File reference EN010072 Glyn Rhonwy Pumped Storage

Meeting with Snowdonia Pumped Hydro Ltd (SPH) Venue

Meeting objectives Project update and draft documents feedback

Schedule of minor changes and feedback - Glyn Rhonwy draft docs review

### Indicative Elevations & Section of Penstock Configuration (Revision 1)

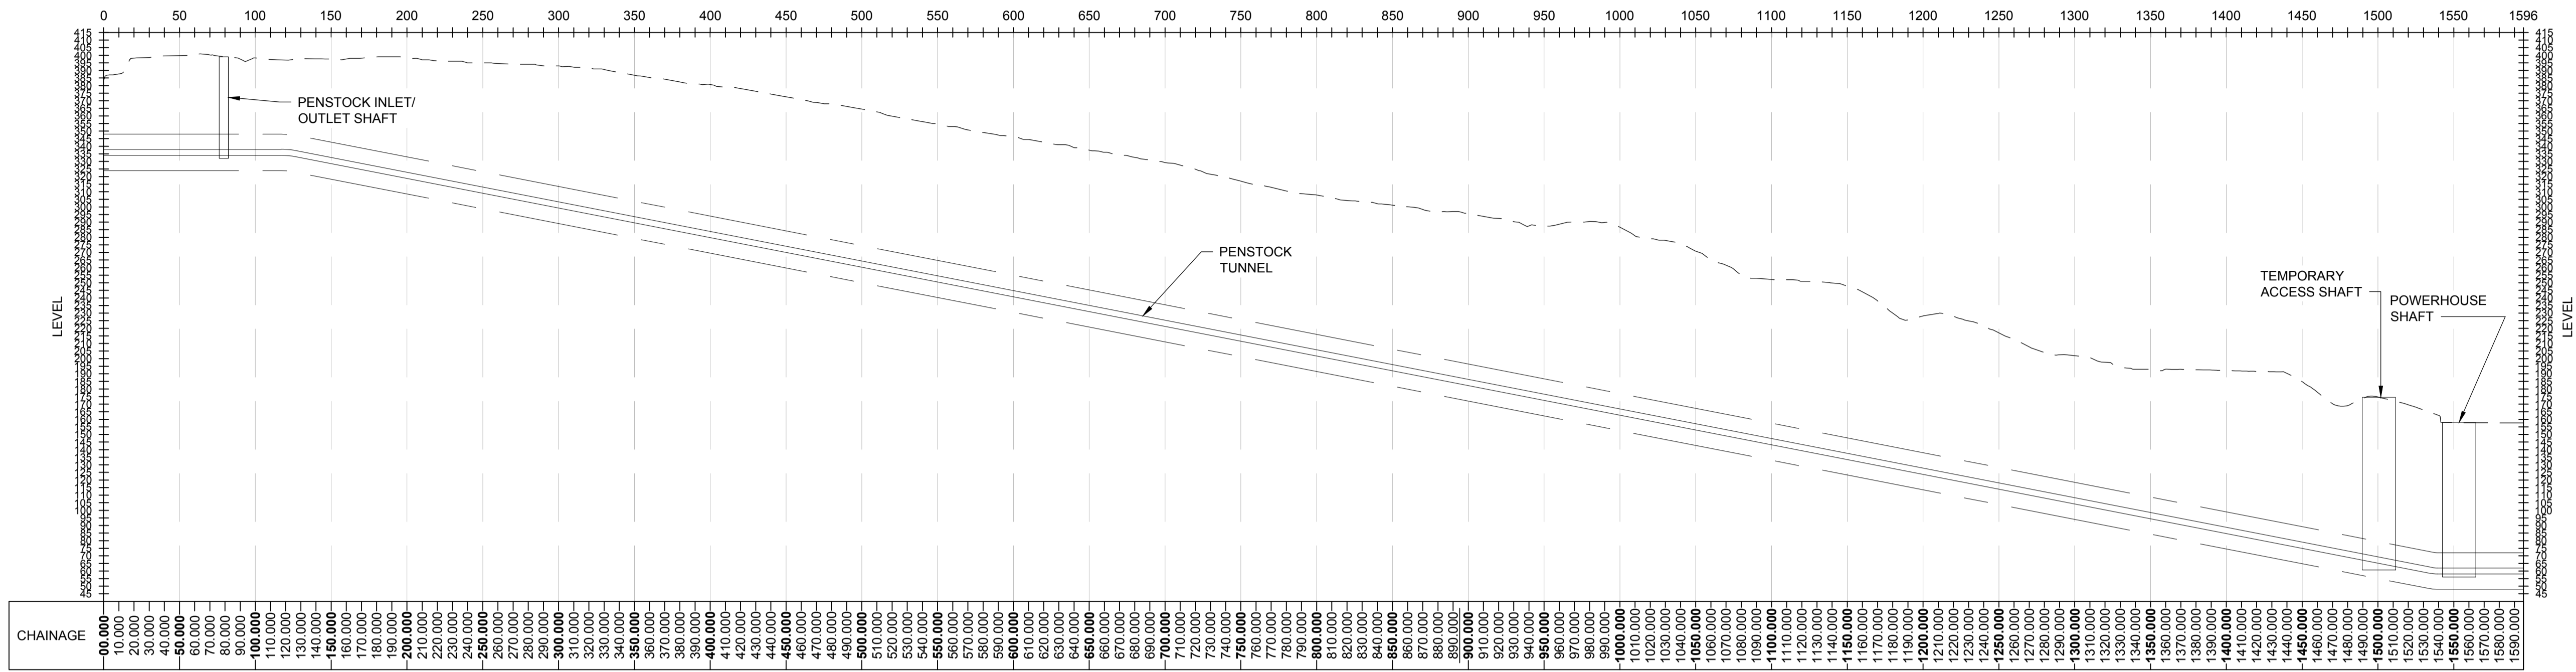
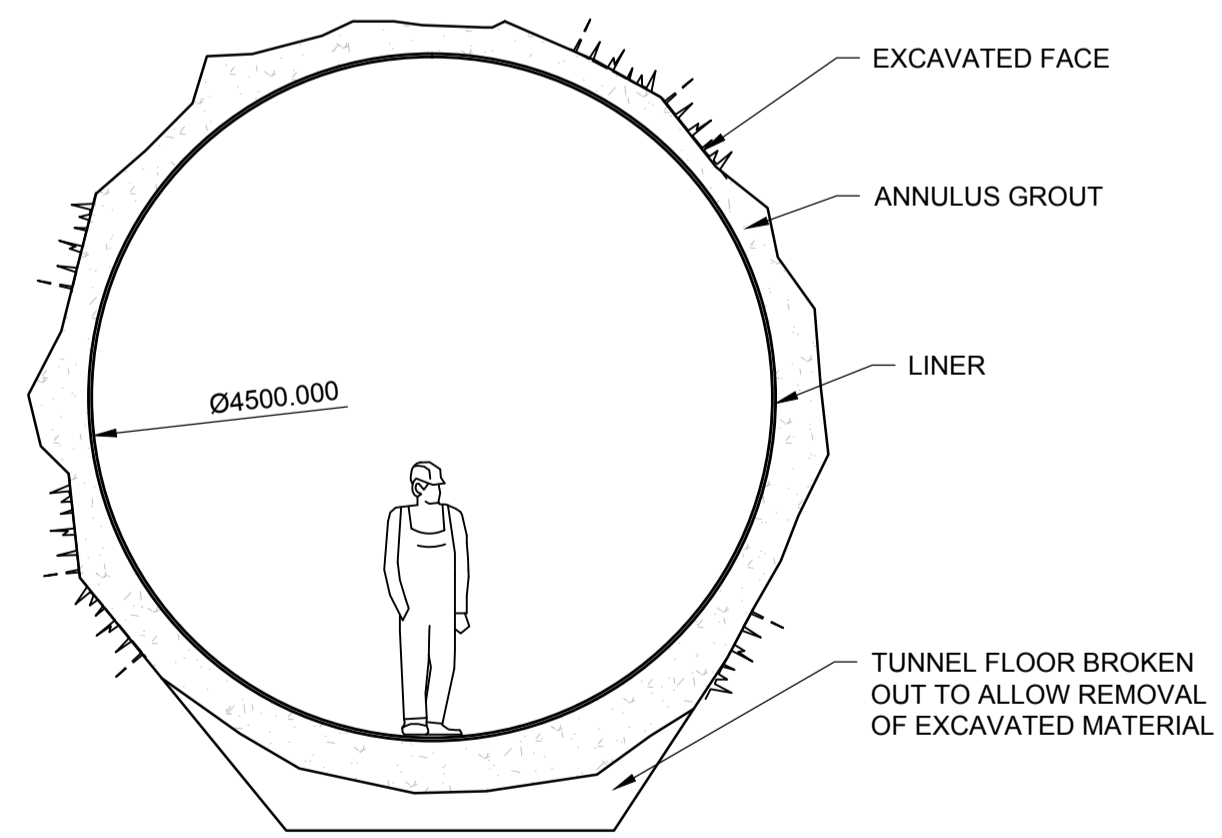
Currently there is no base line depth for the sub-terrestrial works to make Article 6(1)(b) effective. The applicant confirmed that the indicative engineering drawings would provide this. The Inspectorate advised the drafting of the DCO would need to be updated to reflect this and the relevant drawings would need to become a certified document.
